Lime Down

Solar Park

Applicant's Response to SLD Deadline 6 Submission – Transport

Planning Inspectorate Reference: EN010168

Title:
Figure 13-5: Abnormal Load Routes: Solar PV Sites

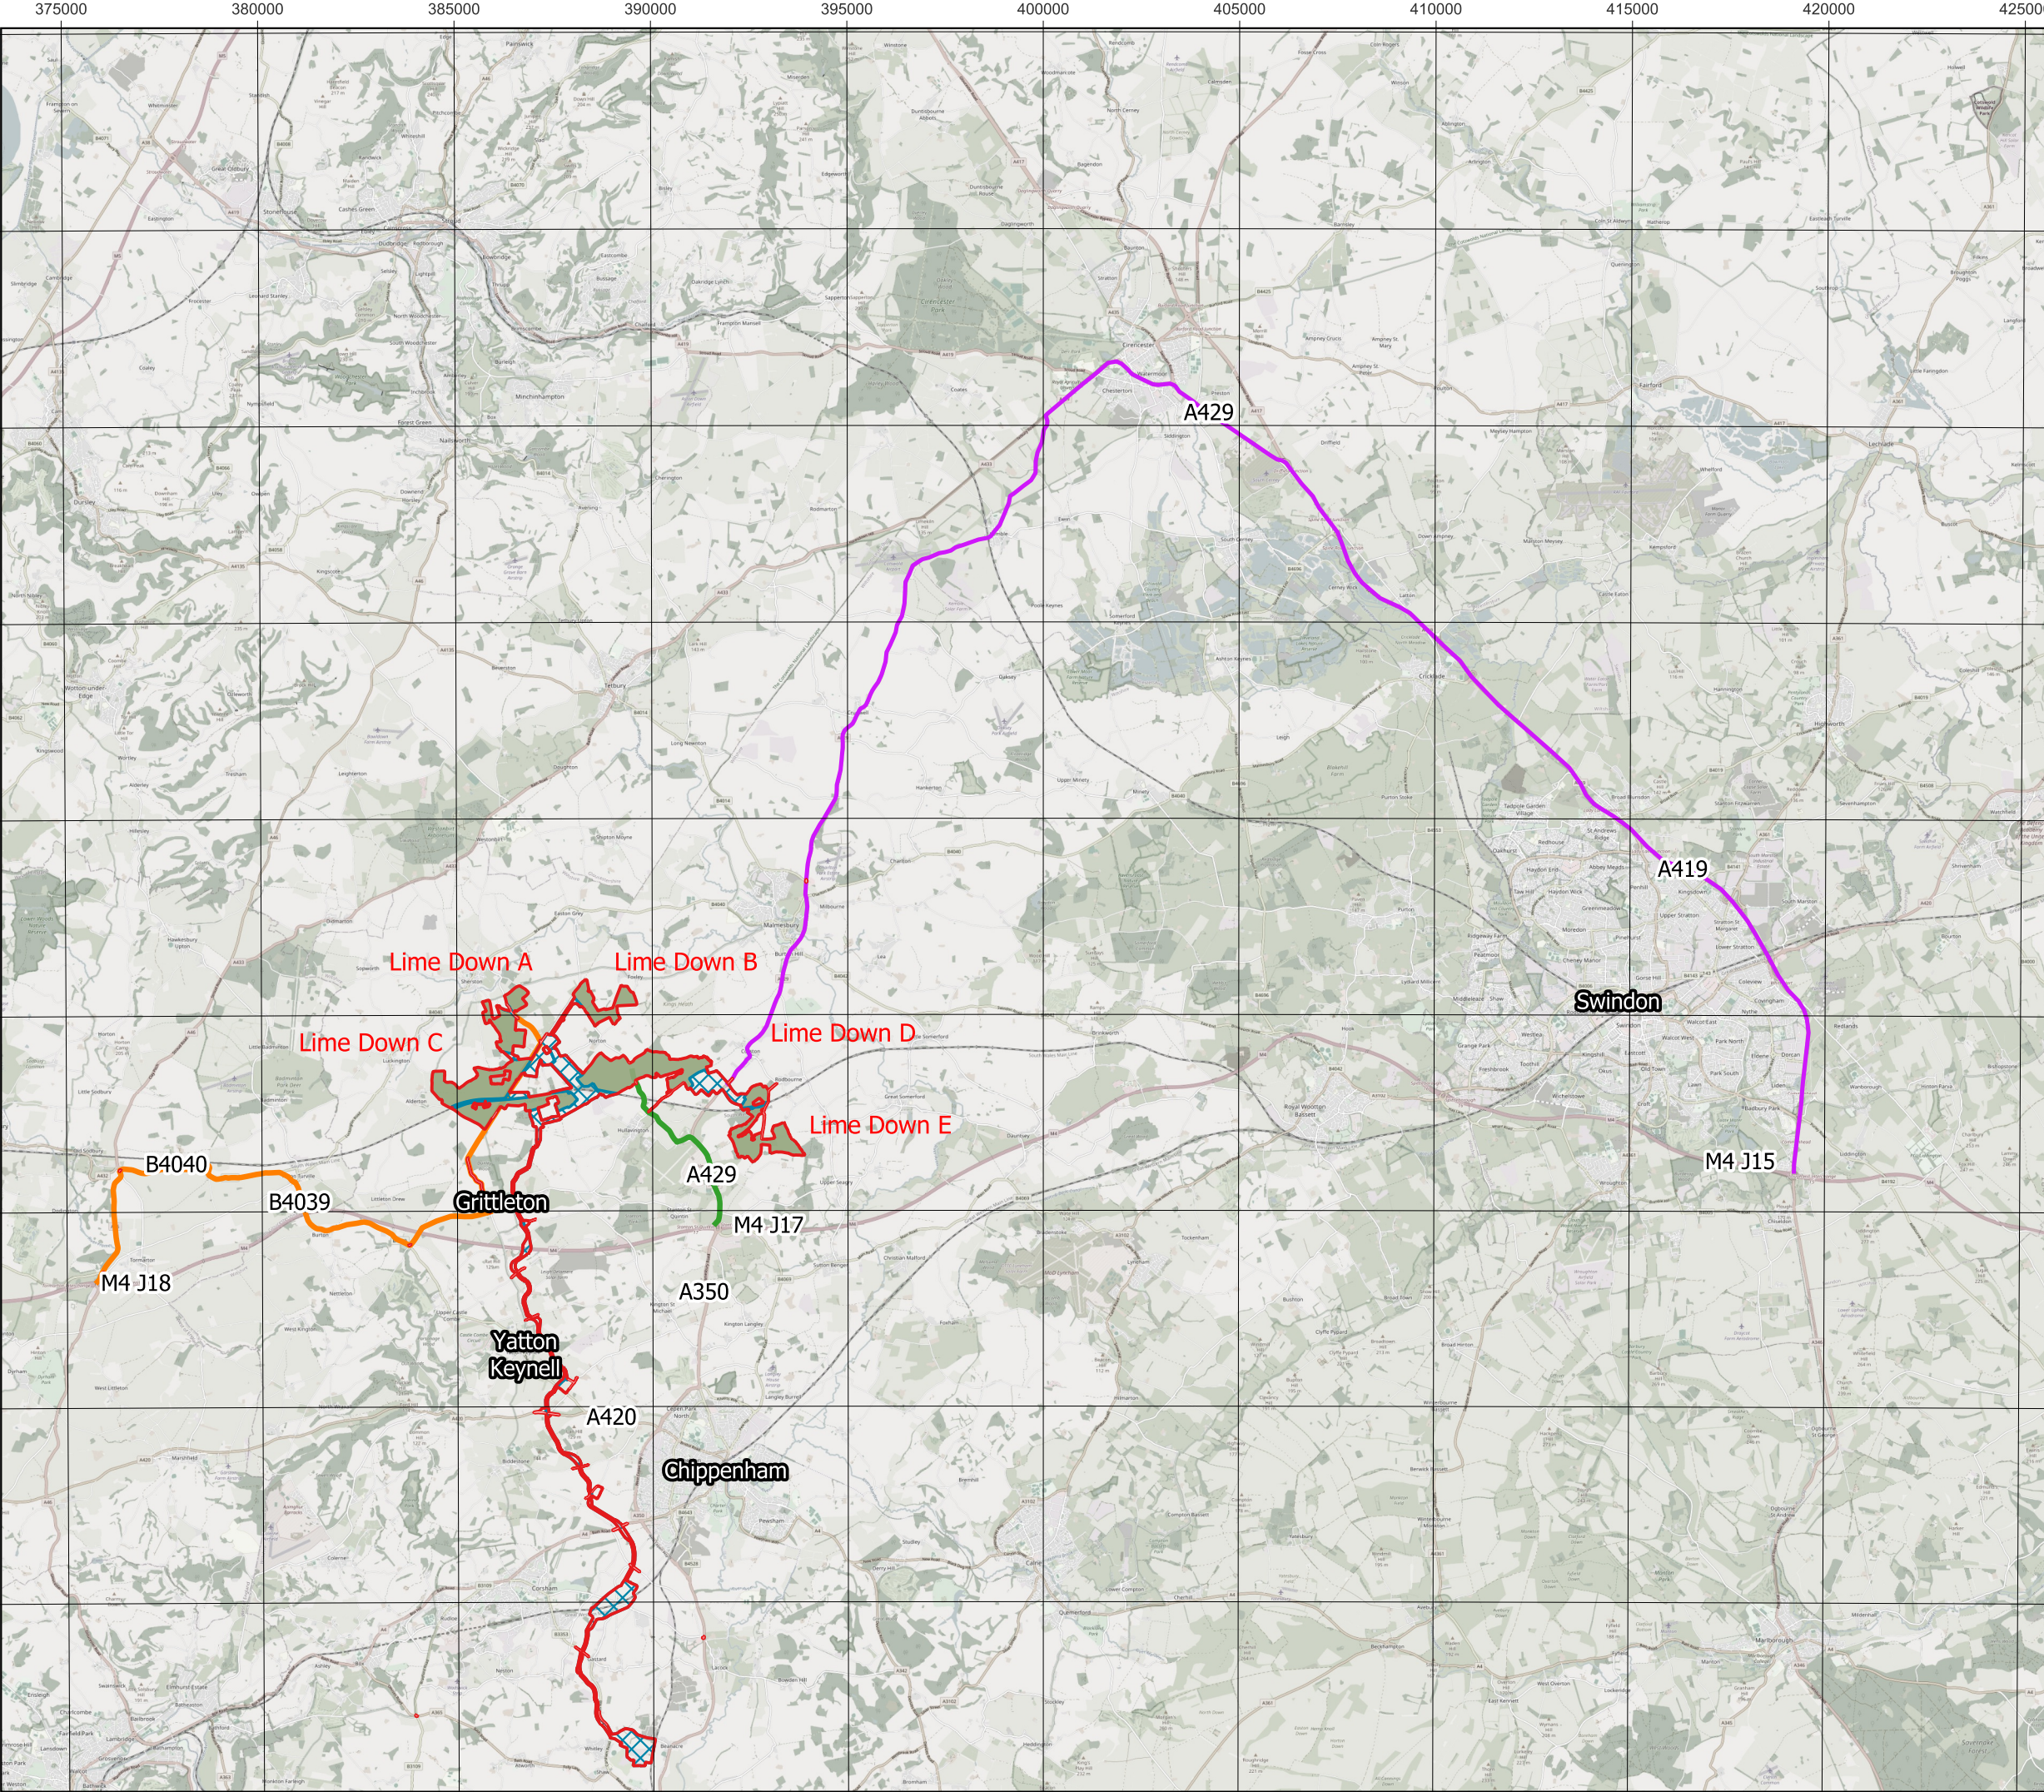
2.2.1 The Applicant has now routed the AIL vehicle from Access 18 on the A429 to the substation at Lime Down E. The revised route avoids Bincombe Wood and passes directly from Access 12 to Access 13.
